PORTISHEAD BRANCH LINE – METROWEST PHASE 1

**Schedule of ExA's recommended amendments to the Applicant's draft DCO
submitted at Deadline (D)6 [REP6-008]**

2.38 - Portishead Station Car Park Layout, Landscaping and New Boulevard and Access Plan

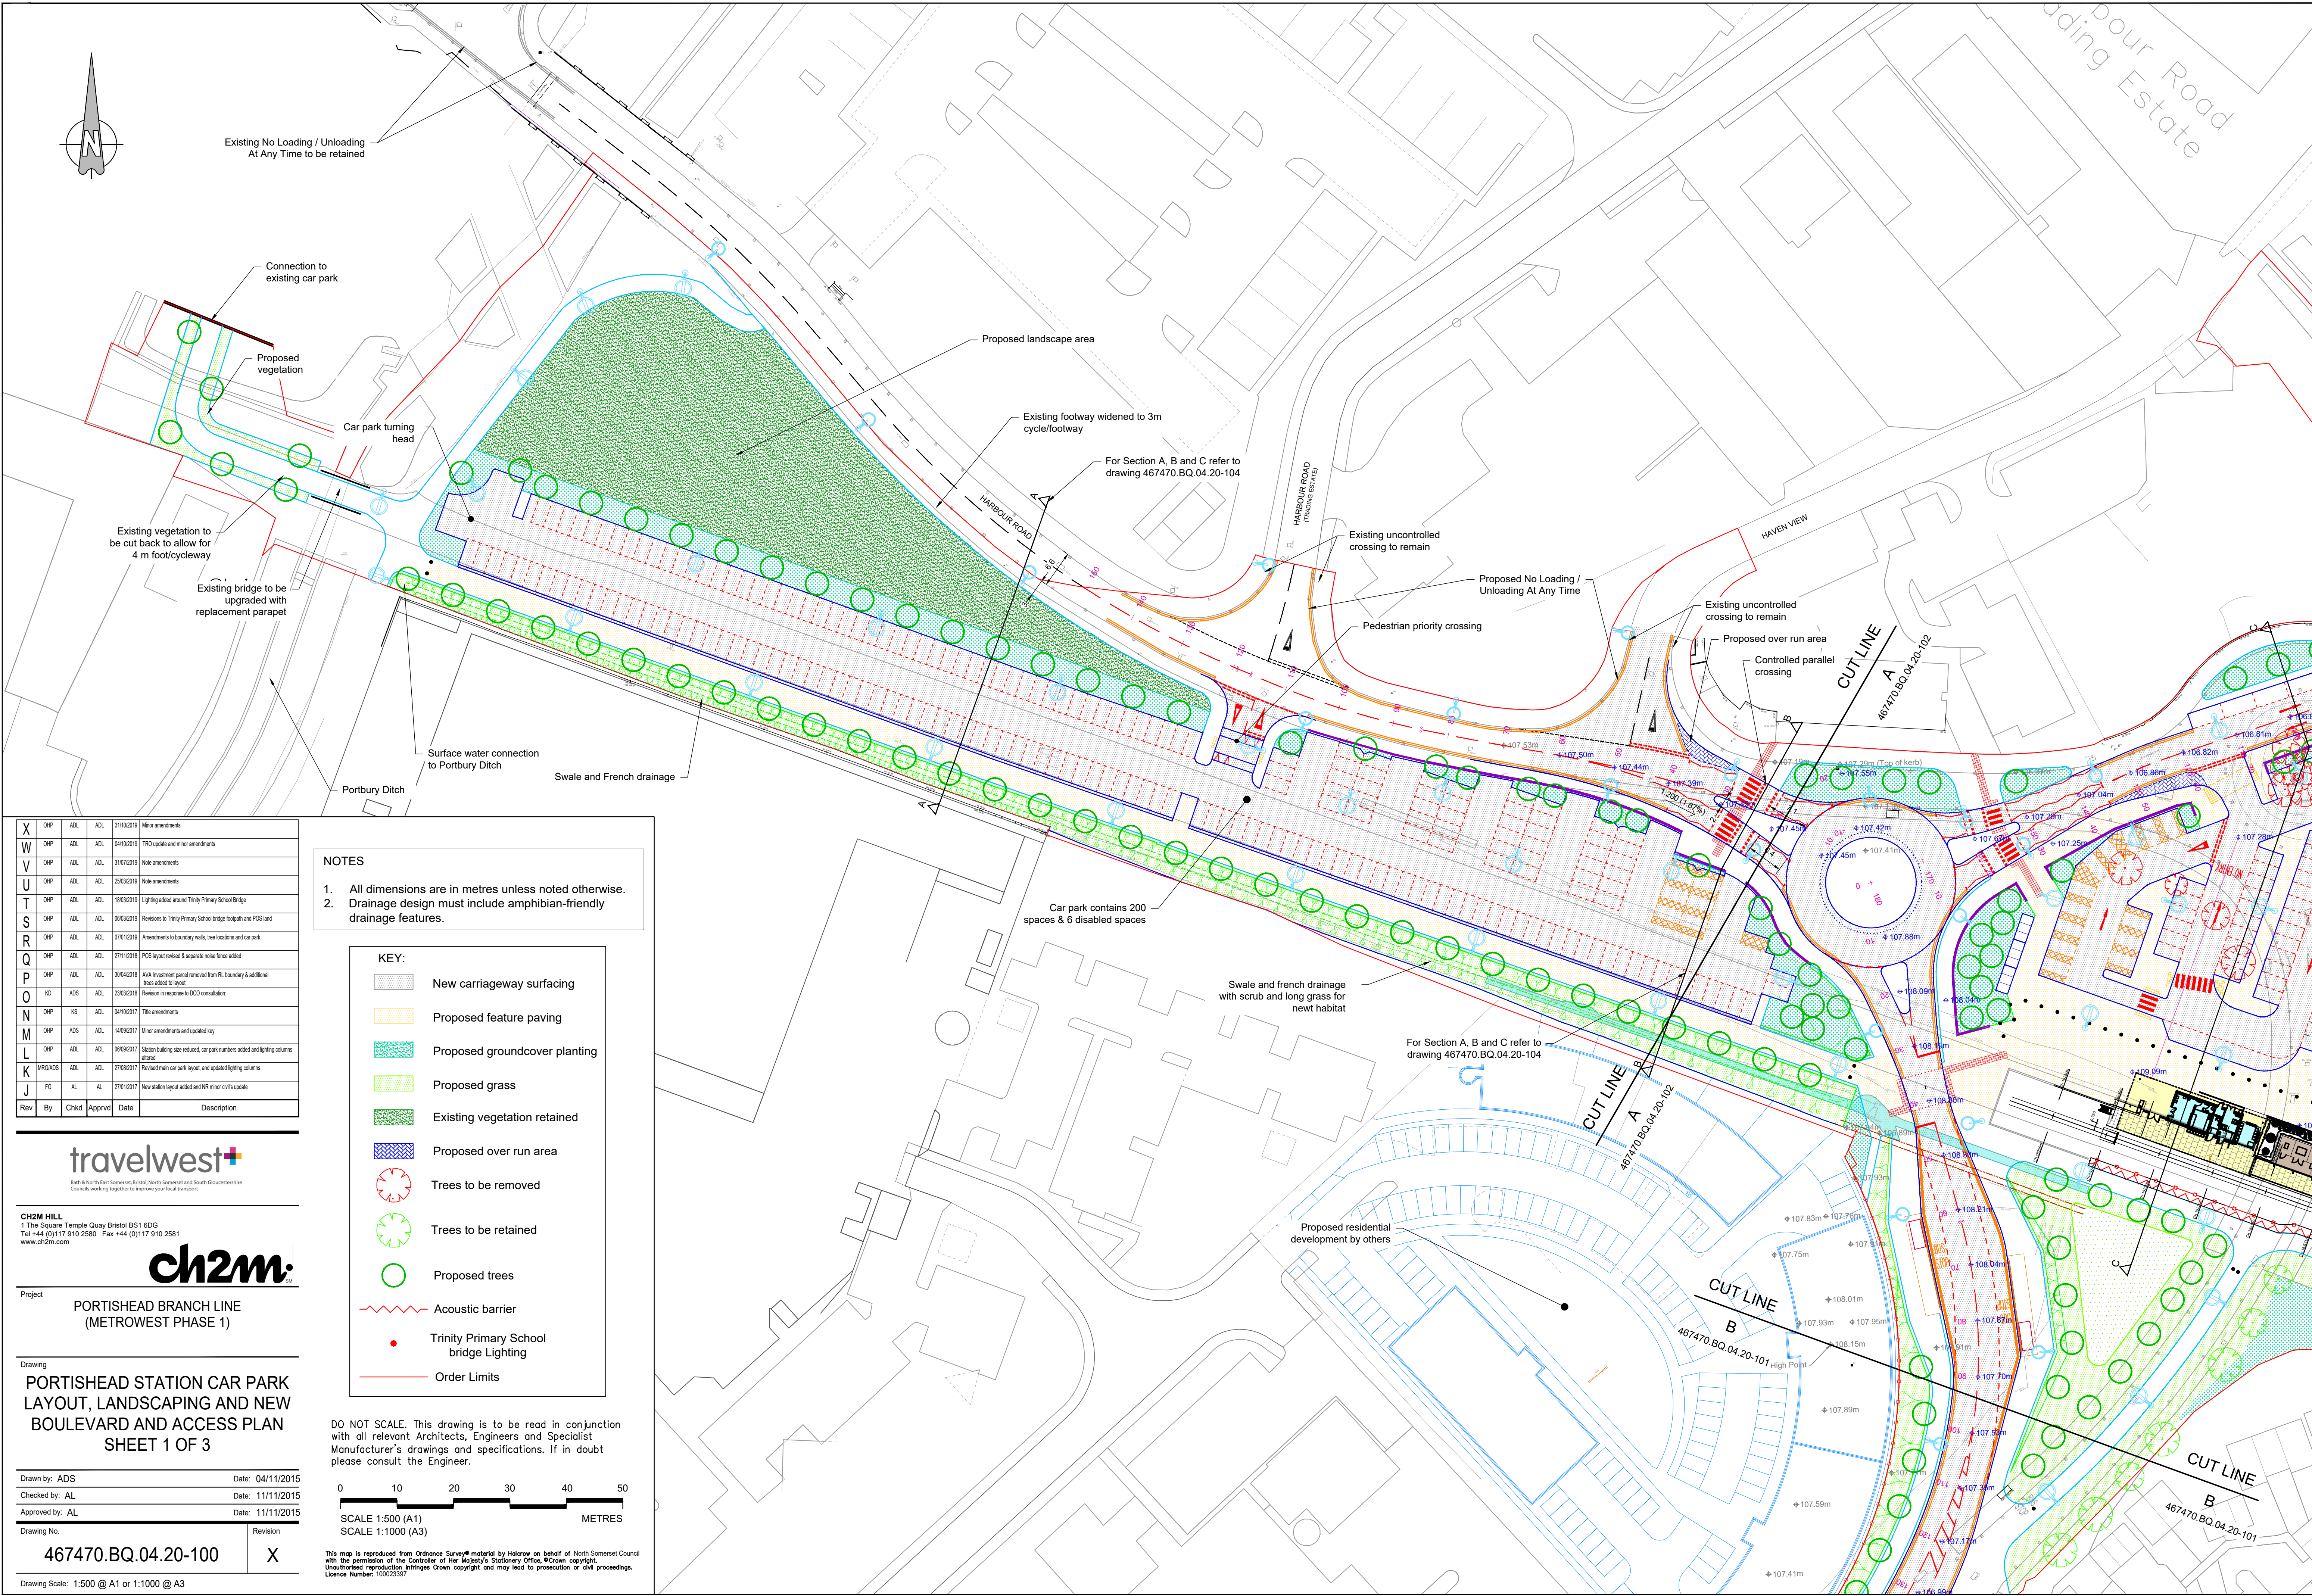
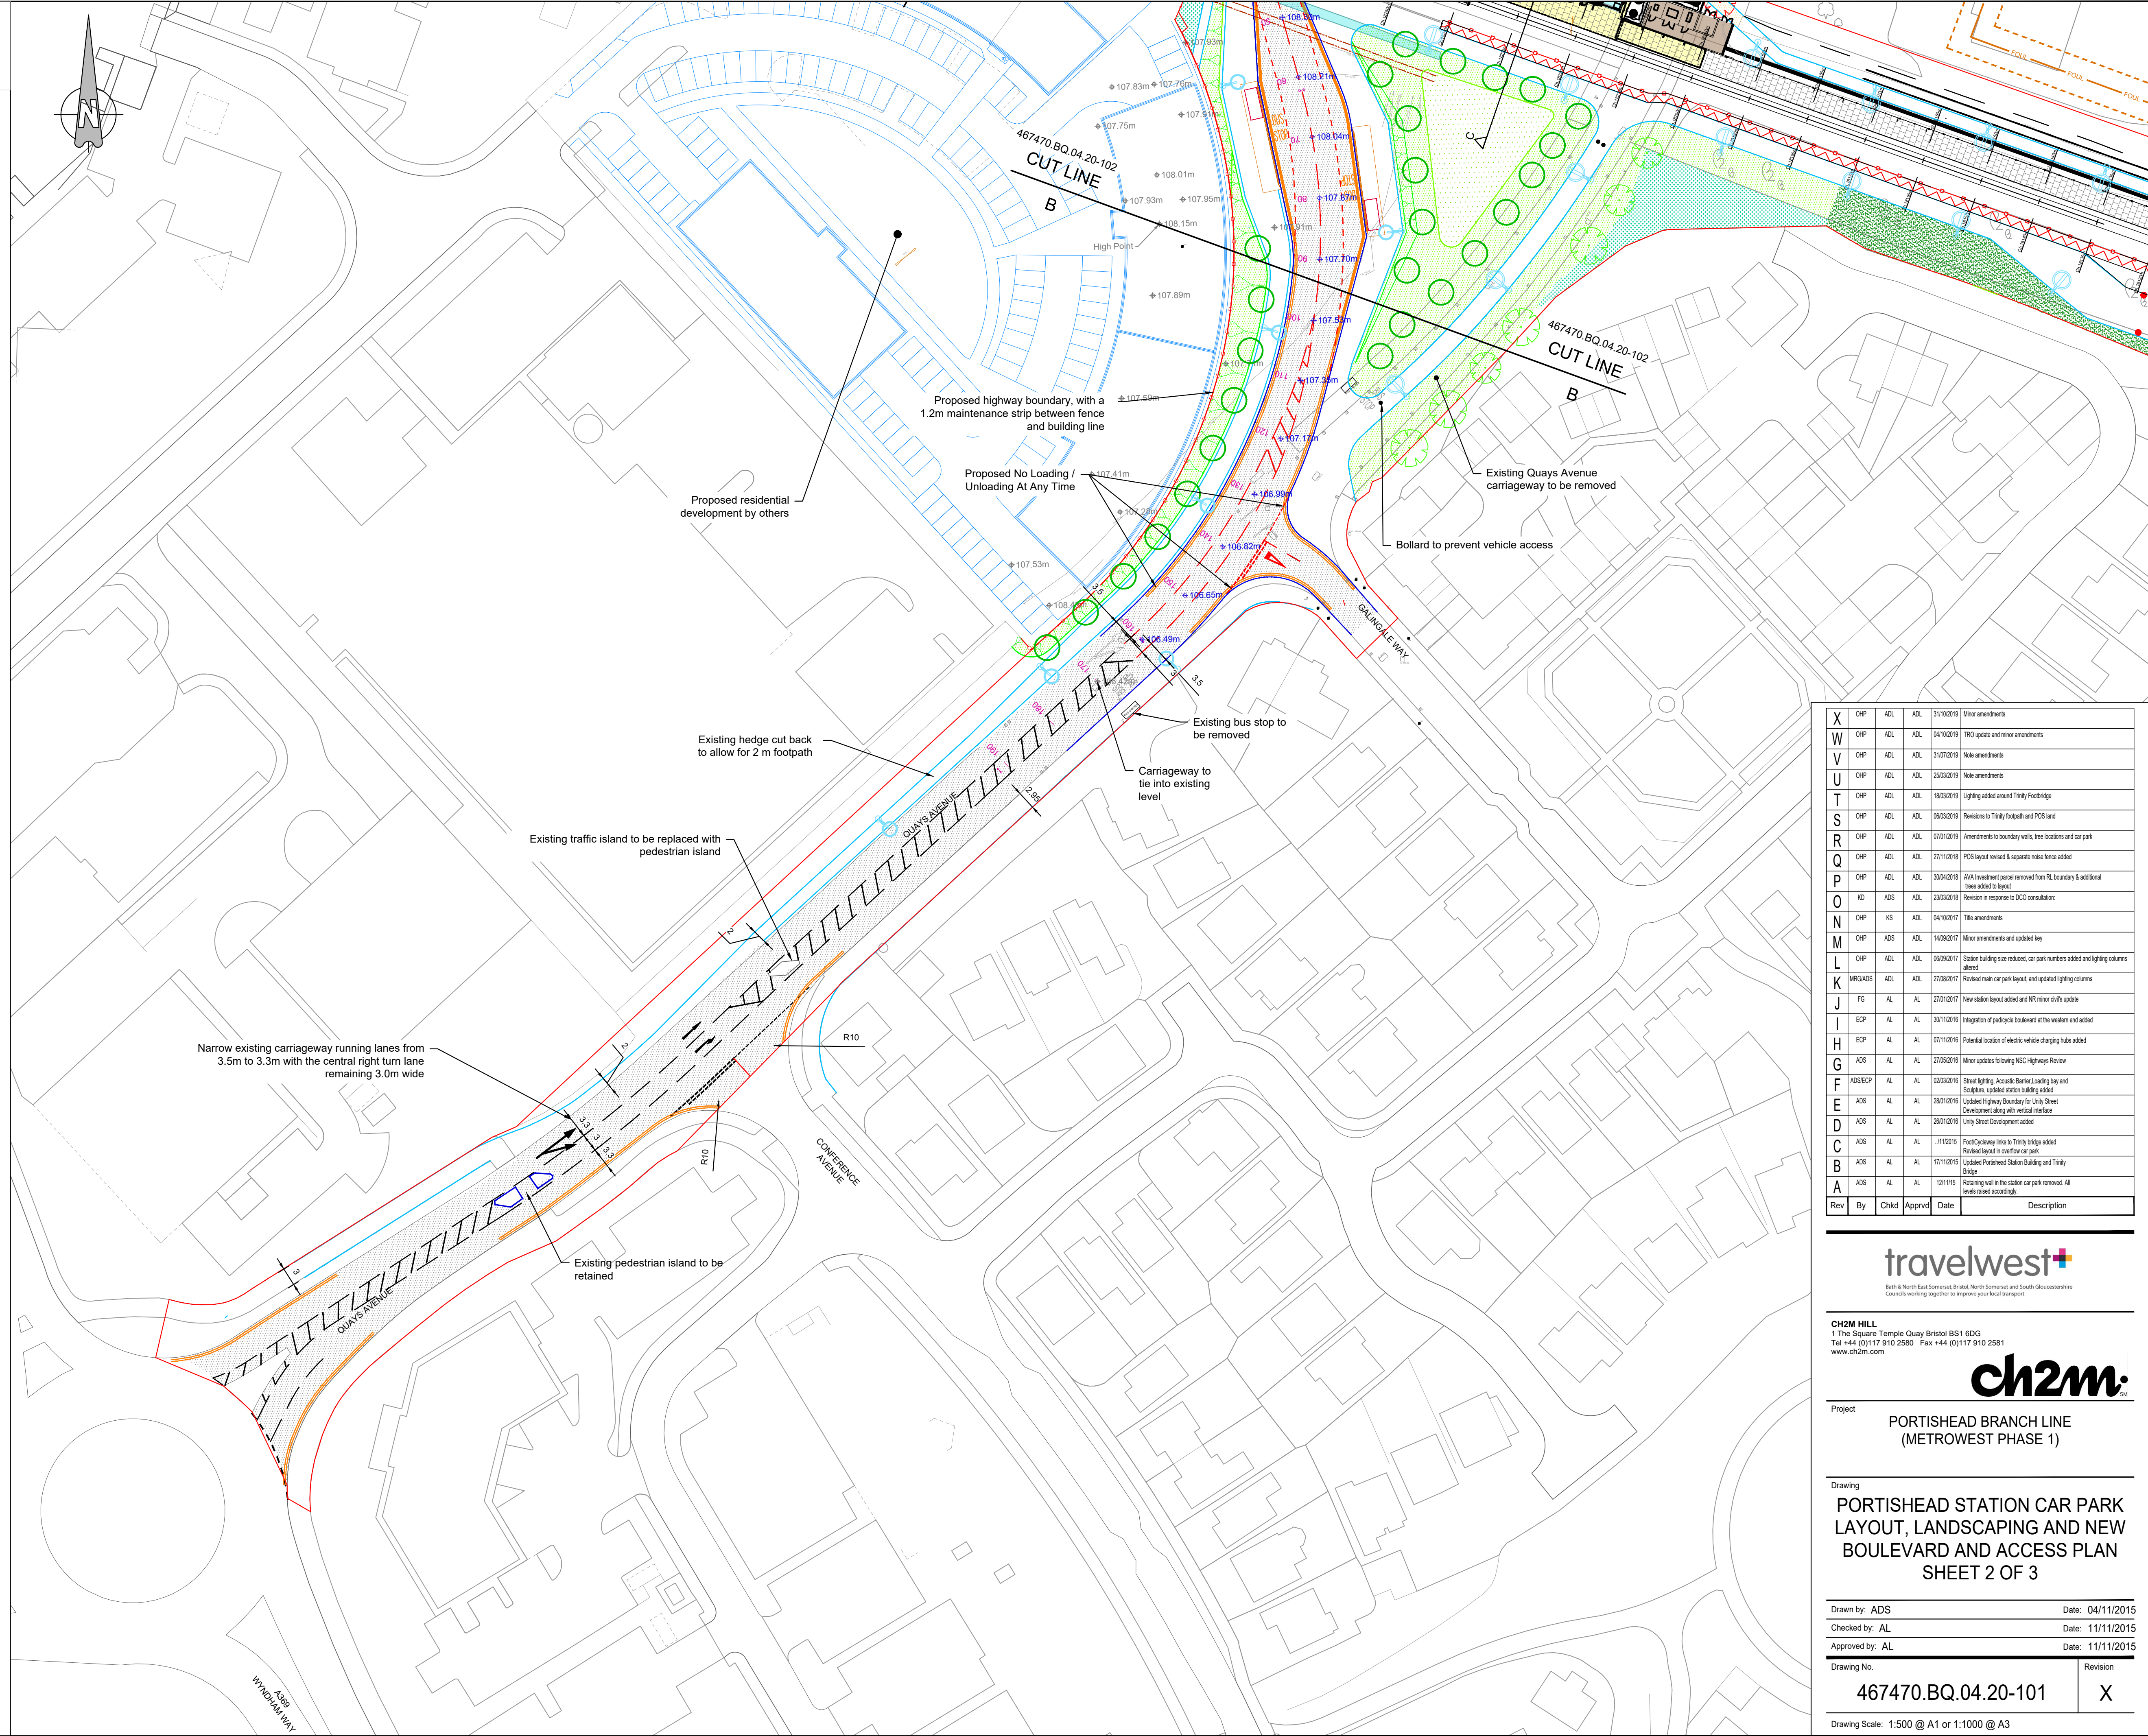
<p>Schedule 2 New Requirement <i>Trinity Primary School Bridge</i></p>		<p>(1) Work No 7 must not commence until details of any permanent lighting to be installed in connection with that work, including measures to minimise light spillage, have been submitted to and approved by the relevant planning authority.</p>	<p>Whilst the ExA note that the submission and approval of detailed design for Trinity Primary School Bridge (Work No 7) would be delivered under Requirement 4 the ExA consider that as for other elements of the scheme (eg Portishead Station which is also included in Requirement</p>

<p>(2) Work No 7 must not commence until details of the colour finish of the bridge have been submitted to and approved by the relevant planning authority.</p> <p>(3) Work No 7 must not commence until details of the location, design and colour of privacy screens, if required, have been submitted to and approved by the relevant planning authority.</p> <p>(4) Work No7 must be carried out in accordance with the approved details and thereafter permanently retained.</p>	<p>4) should the Secretary of State (SoS) grant consent then given the concerns raised during the Examination in relation to this work it is important that details in relation to permanent lighting; colour of the bridge and location, design and colour of privacy panels for the bridge are submitted for approval</p>
<p>Schedule 2 New Requirement <i>Perimeter Track between Marsh Lane and the compounds under the M5 Avonmouth Bridge and on Lodway Farm</i></p>		<p>(1) Work Nos 16A and 17 must not commence until:</p> <p>(a) a pre-commencement survey of the perimeter track between Marsh Lane and Work Nos 16A and 17 has been undertaken and submitted to and approved by the relevant planning authority. The pre-commencement survey shall include but not be limited to:</p>	<p>The ExA consider that should the SoS grant consent the use of the perimeter track to access Work Nos 16A and 17 should not result in damage to this track and the track itself should be capable of accommodating the weight and volume of construction traffic that would need to use it</p>
